**Response to Planning application from Hertfordshire County Council (T and CP GDP Order 2015)**

District ref: 6/2021/0314/FULL  
HCC ref: WH/5717/2021  
HCC received: 12 February 2021  
Area manager: Matthew Armstrong  
Case officer: Paul Marshall

22 CHURCH LANE NORTHAW POTTERS BAR EN6 4NX

Erection of a 5 bedroom detached house

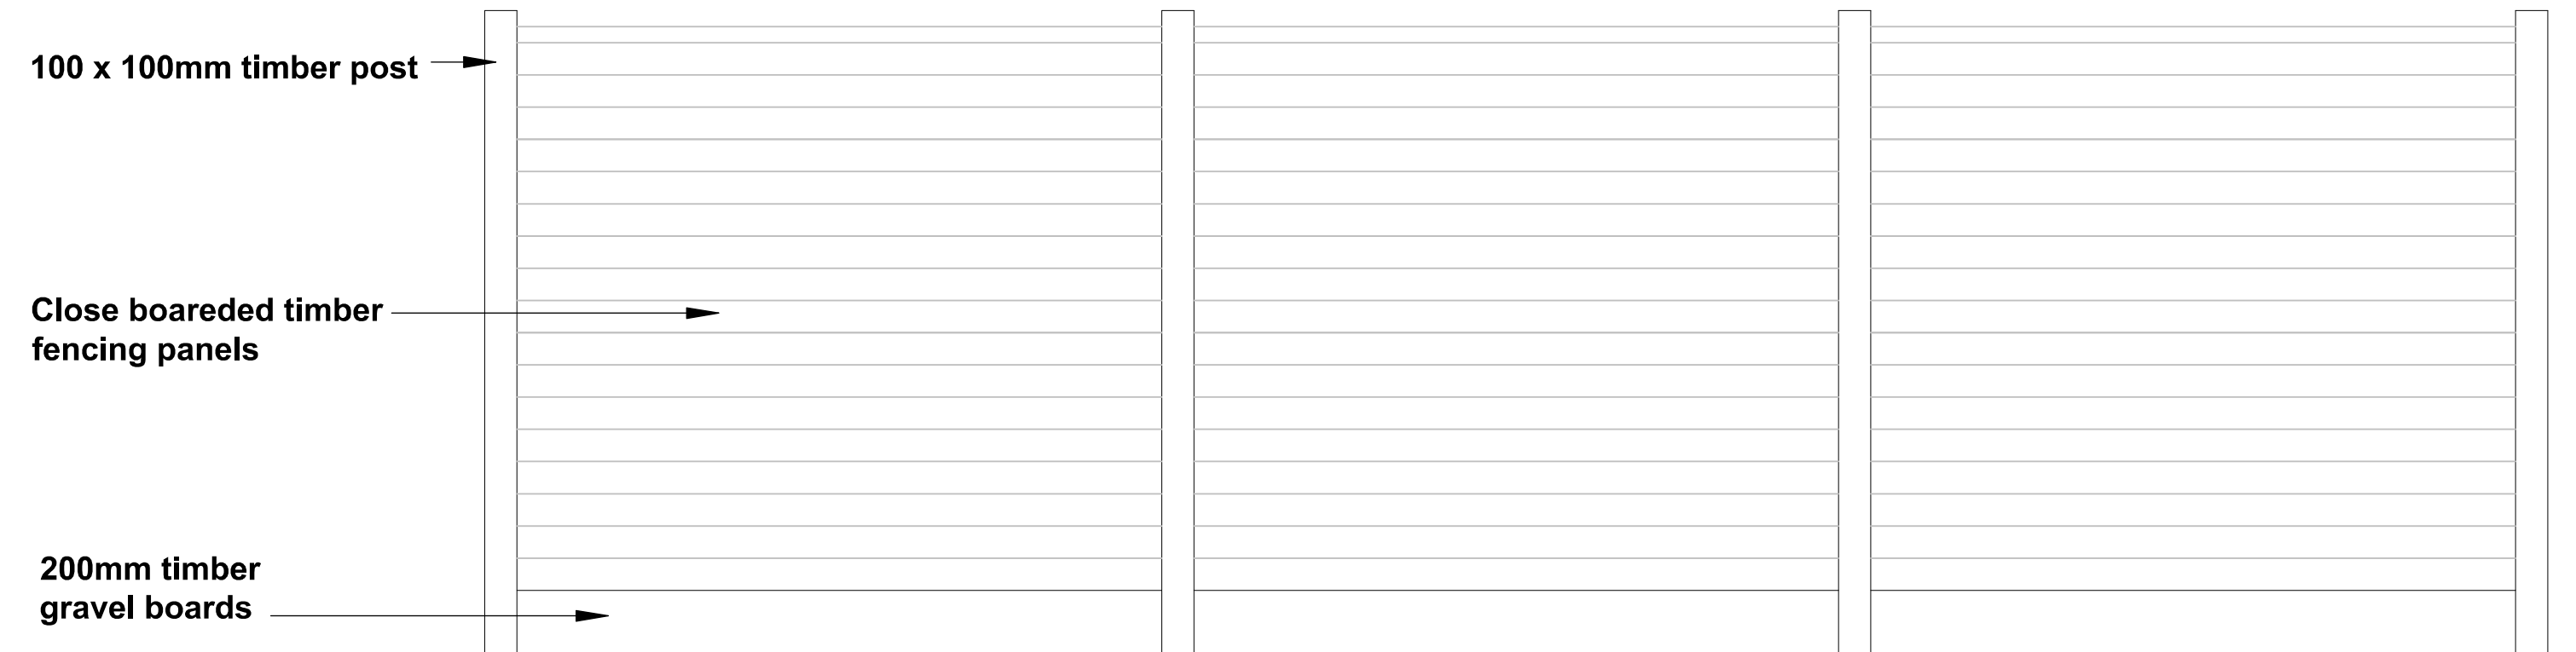
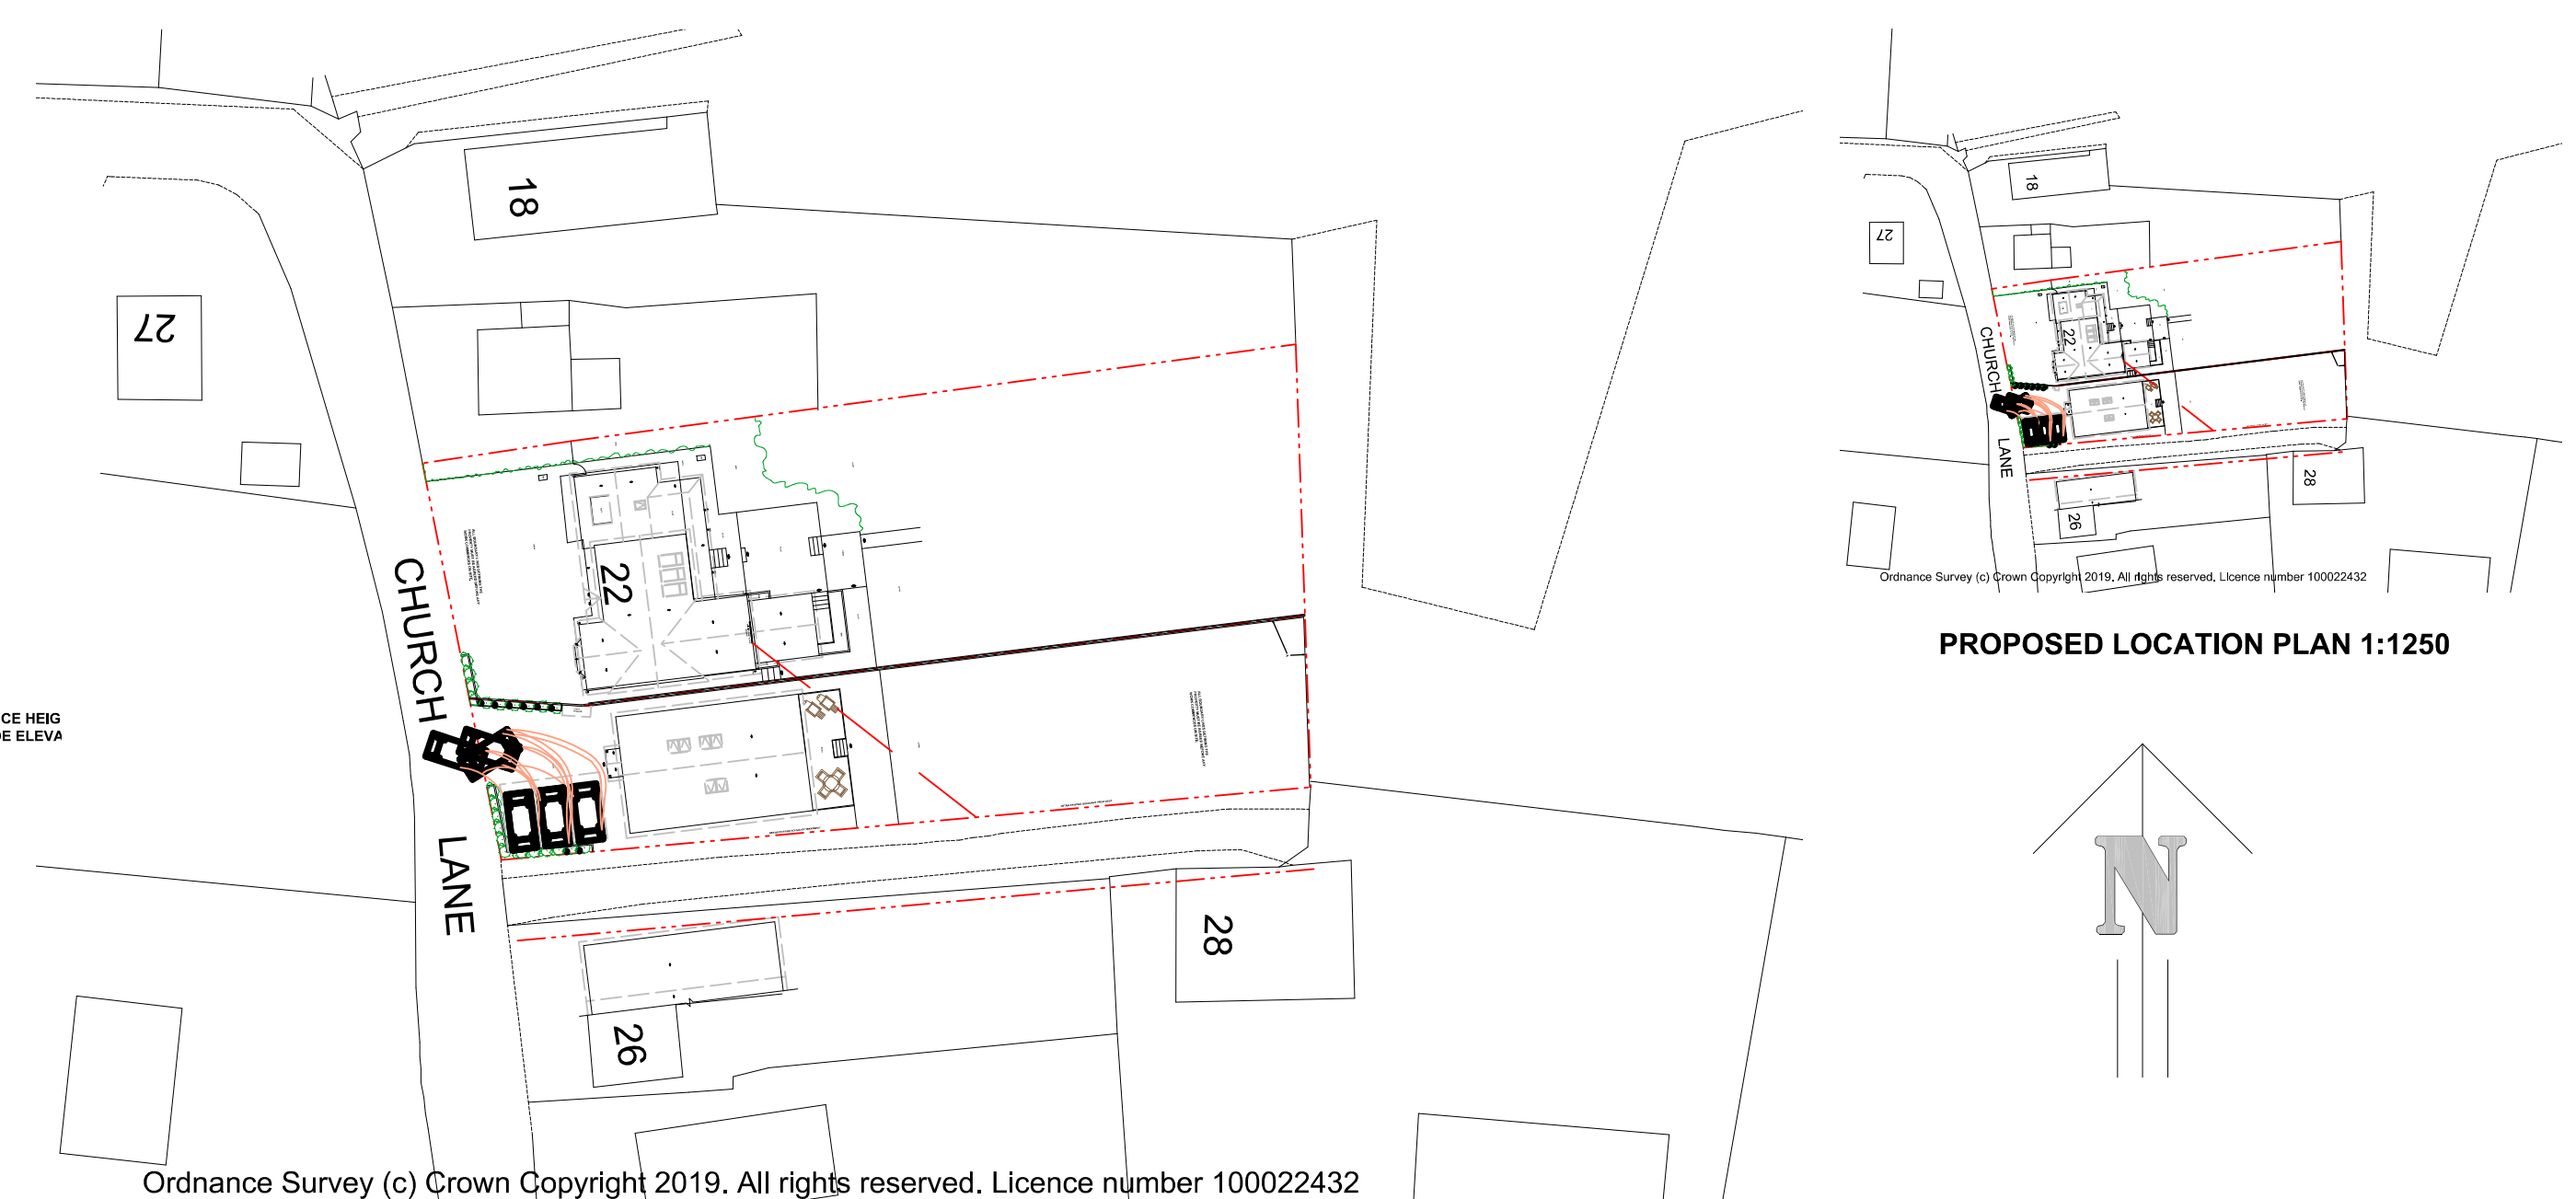
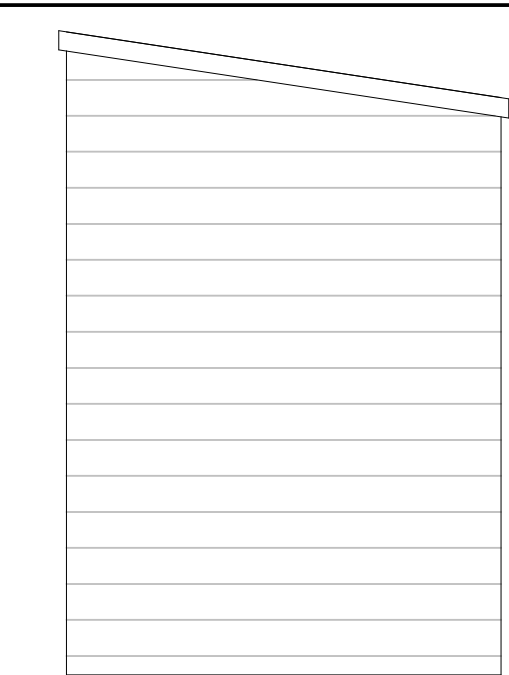
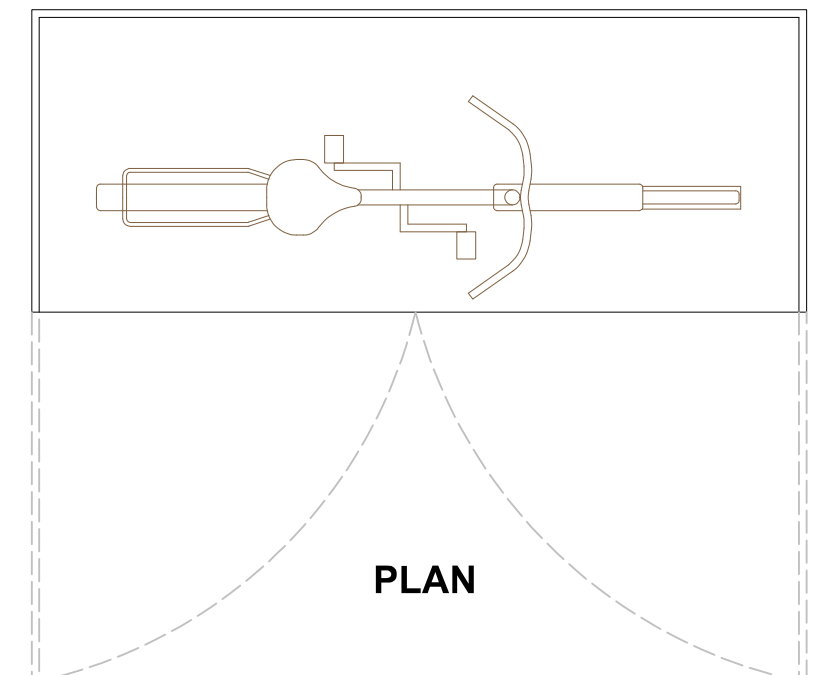
The parking layout is extremely tight, drawing 2019/1327/4 shows the tracking for 3 parked vehicles with some of the tracked lines over running. There is no way to confirm the tracking. A swept path analysis should be provided with the standard size vehicle. I would expect to see at least 4.571 (Skoda Octavia or similar) model.

I note from the application form section 8 that no new access is proposed. However, drawing 2019/1327/4 demonstrates an access for the new dwelling. A detailed vehicle crossing should be provided with a visibility splay.
